Appeal Decision

Decision date: 18 August 2021

Appeal Ref: APP/R5510/D/21/3270895

25 Angle Close, Uxbridge UB10 0BS

GDC DESIGN LTD CHARTERED ARCHITECT Tel: 01895 610 932 Mob: 07976 732 636 g.g.c@btinternet.com			
PROJECT 25 ANGLE CLOSE, HILLINGDON UB10 0BS LOFT CONVERSION			
DESCRIPTION PROPOSED ELEVATIONS			
SCALE 1:100 @ A3	DRAWN BY JT	CHECKED BY GC	DATE 28/08/20
DRAWING No. 25 ACL / P2 / 06			REV.

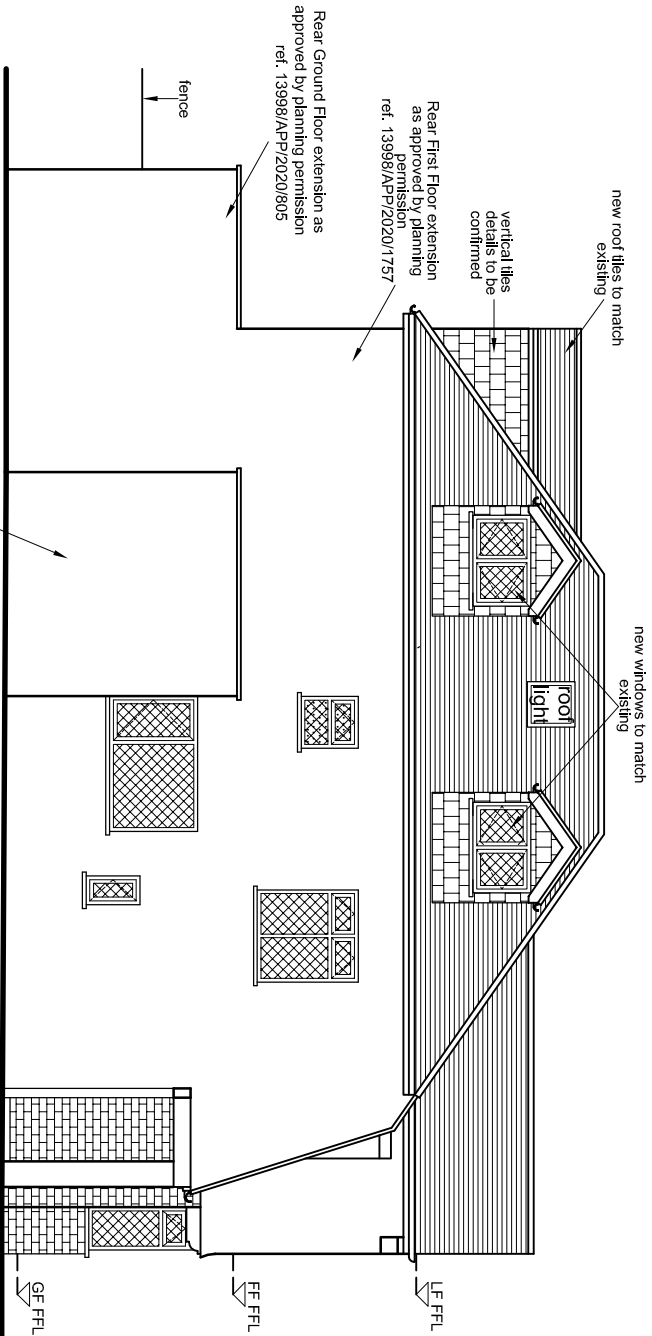
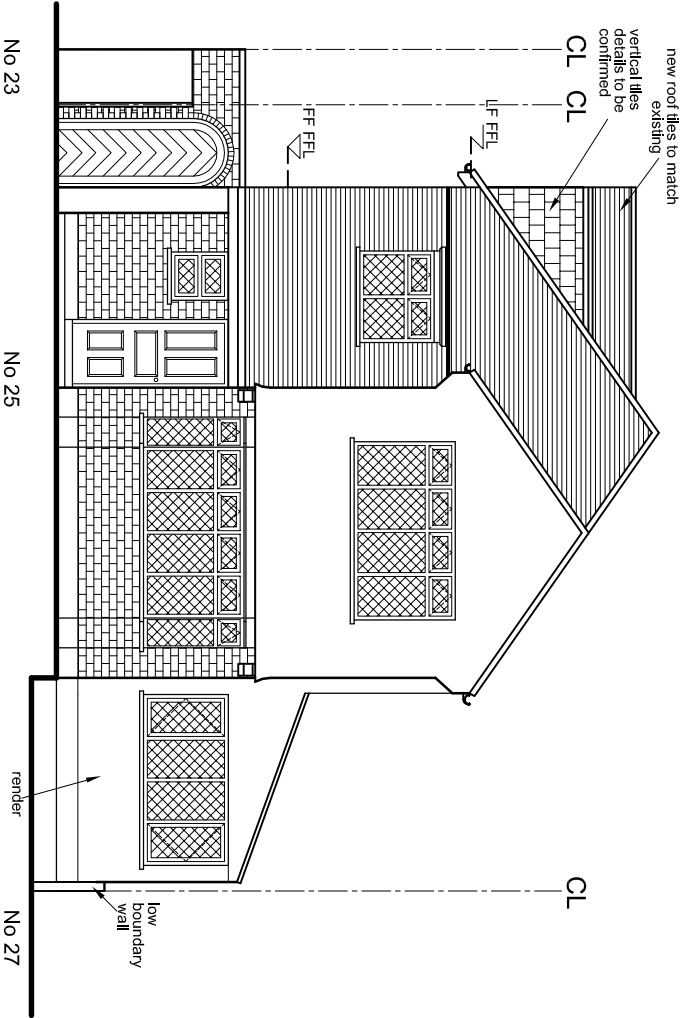
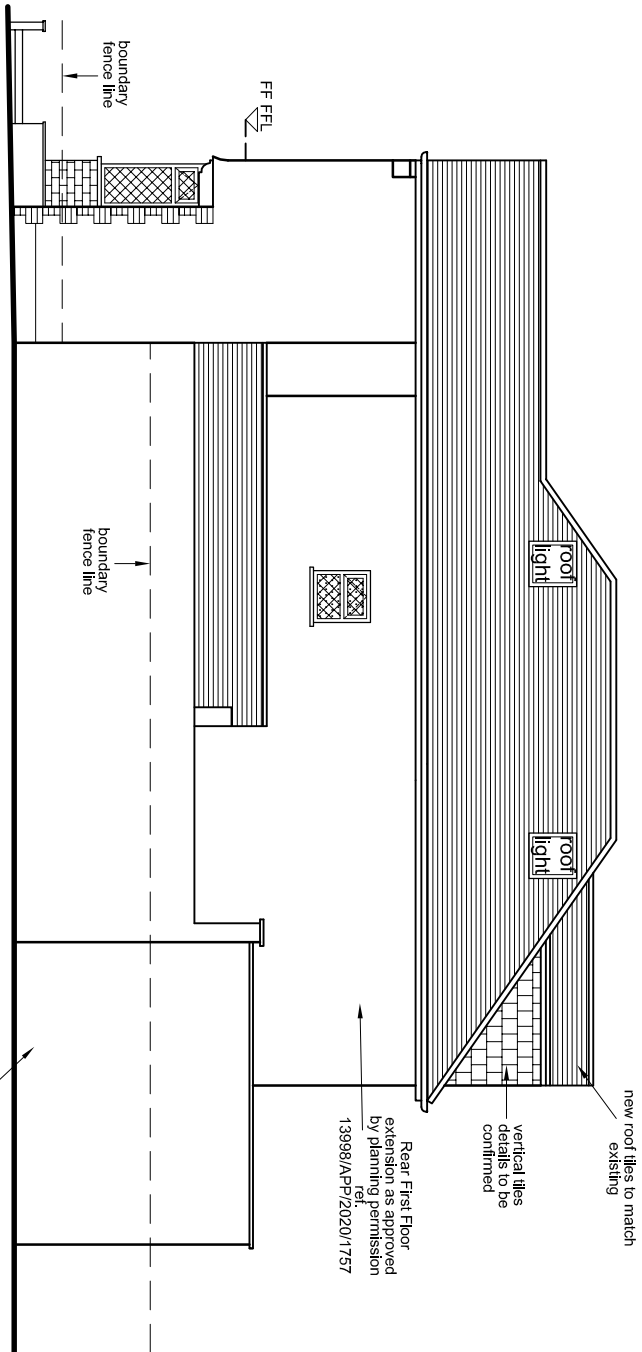
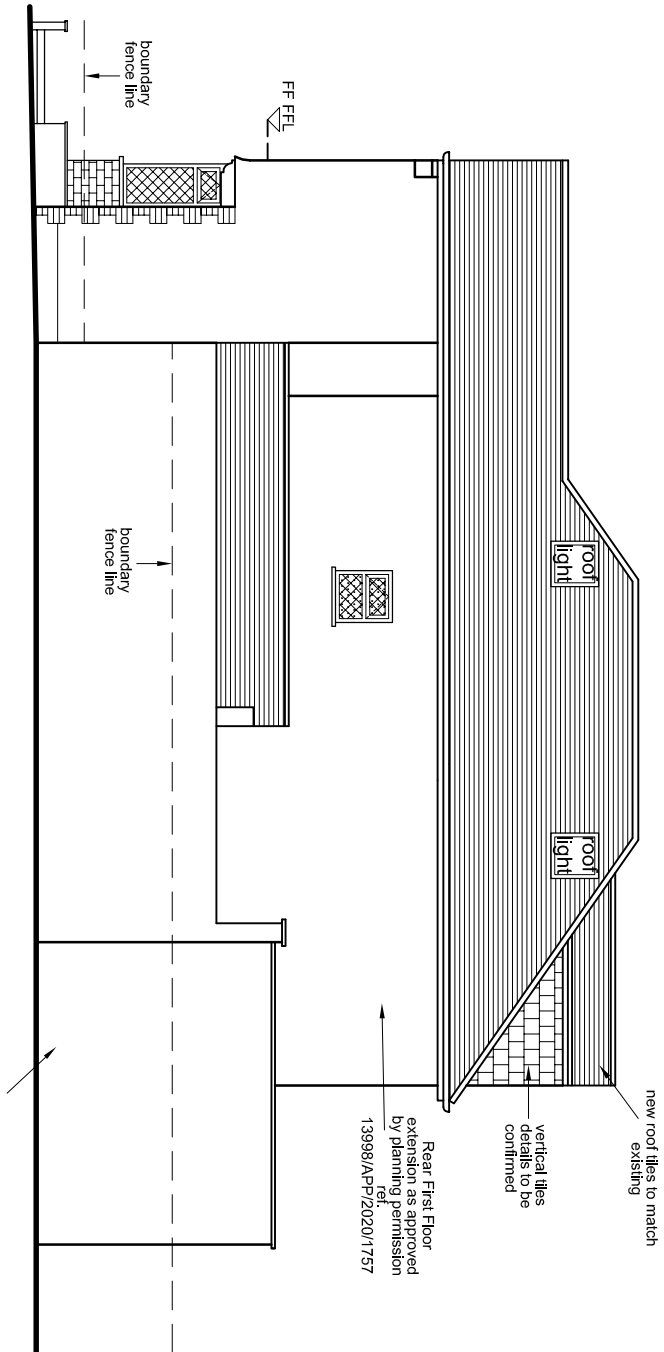
5. Due to the host dwelling's projecting gable and its location in the corner of a cul-de-sac, the far side of the dwelling is not readily visible when travelling through Angle Close towards the site. One dormer window would be located to the rear and one to the side. The proposed dormer windows are modest in scale in relation to the host dwelling with the side dormers being set back from the front of the property and both dormers being set down from the ridge.

6. Although the proposed side dormer would be visible when stood in front of the dwelling it would not be so conspicuous so as to be a visually prominent form of development that would materially alter the character and appearance of the street scene or host dwelling. The assimilation of the proposal into the existing street scene and host dwelling would be assisted by the use of windows and roof tiles to match those of the host property.

8. Third parties have raised concern about the potential for overlooking of their garden from the proposed side dormer window. I accept that the addition of the dormer windows could increase overlooking. Therefore, as it is high level and would be used for light into a stairwell and a bedroom, where a further window and roof light would be provided, I see no reason why the side dormer window could not be obscure glazed. This would mitigate any overlooking and thus there would be no loss of privacy from the side dormer window.

- 3) The development hereby permitted shall not be occupied until the dormer window on the southern (side) elevation has been fitted with obscured glazing, and no part of that window that is less than 1.7 metres above the floor of the room in which it is installed shall be capable of being opened. Details of the type of obscured glazing shall be submitted to and approved in writing by the local planning authority before the window is installed and once installed the obscured glazing shall be retained thereafter.

10. In order to safeguard the living conditions of neighbouring residents, a condition will also be attached to ensure the two side dormer windows are obscure glazed. The appellant has outlined the acceptability of such a condition in their grounds of appeal.

25 ACL / P2 / 04

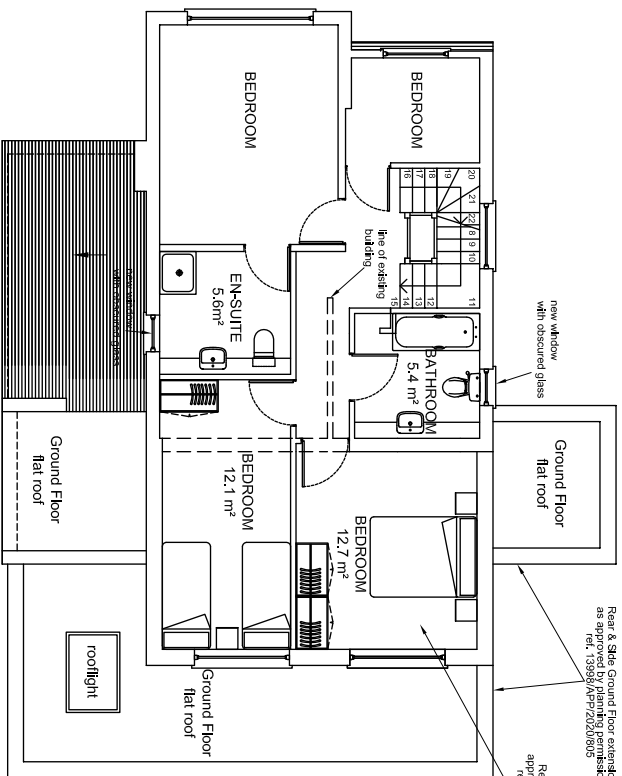
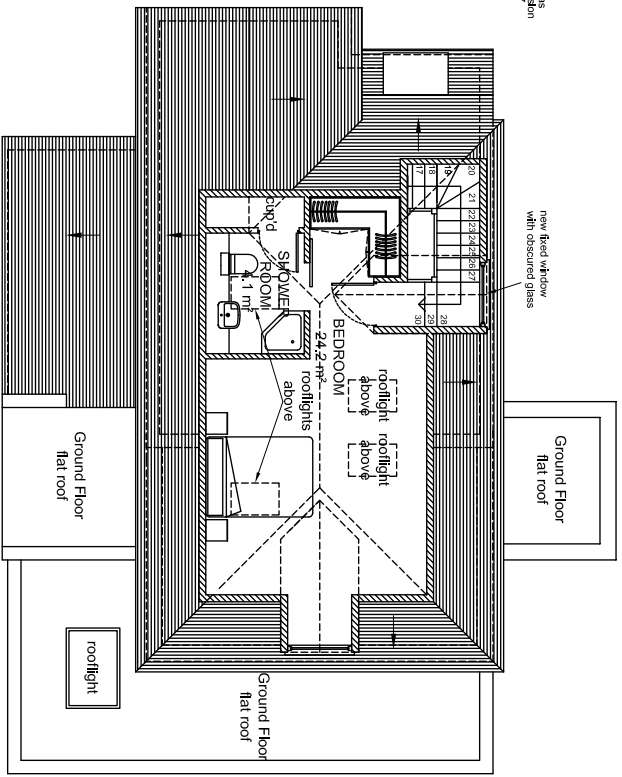
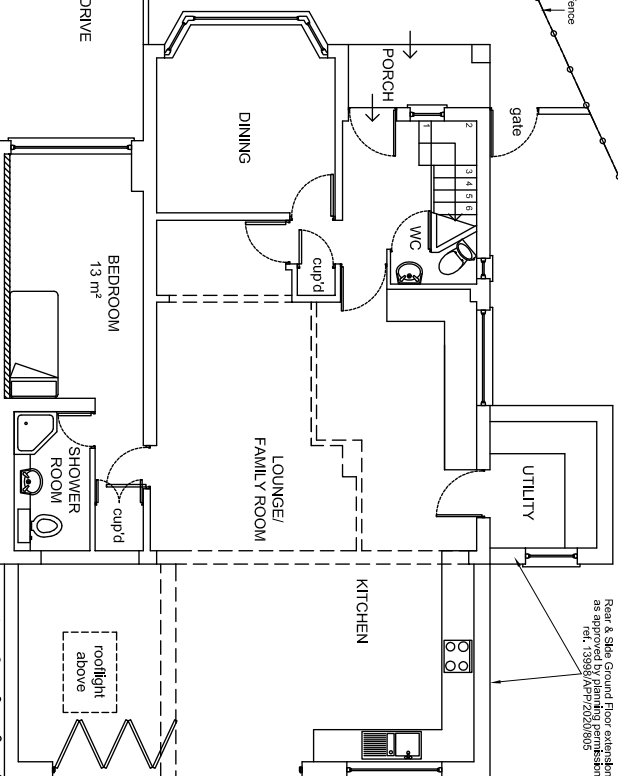
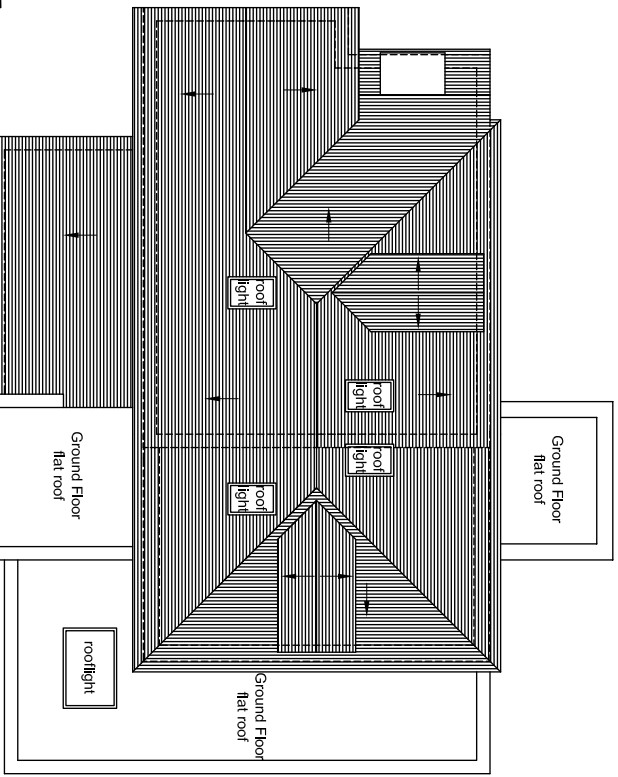
application. I have reviewed the plans which only detail the addition of dormer windows and rooflights as a difference between the existing and proposed plans.

accordance with the approved plans. I note that the plans were altered during the course of the application and the plan numbers have remained the same. However, both the appellant and the Council have confirmed that their assessment was based on the plans detailing two dormer windows not three and I have determined the appeal on those plans.

- 1) The development hereby permitted shall not begin later than 3 years from the date of this decision.
 - 2) The development hereby permitted shall be carried out in accordance with the following approved plans: 25 ACL/P2/01, 25 ACL/P2/04 A and 25 ACL/P2/06
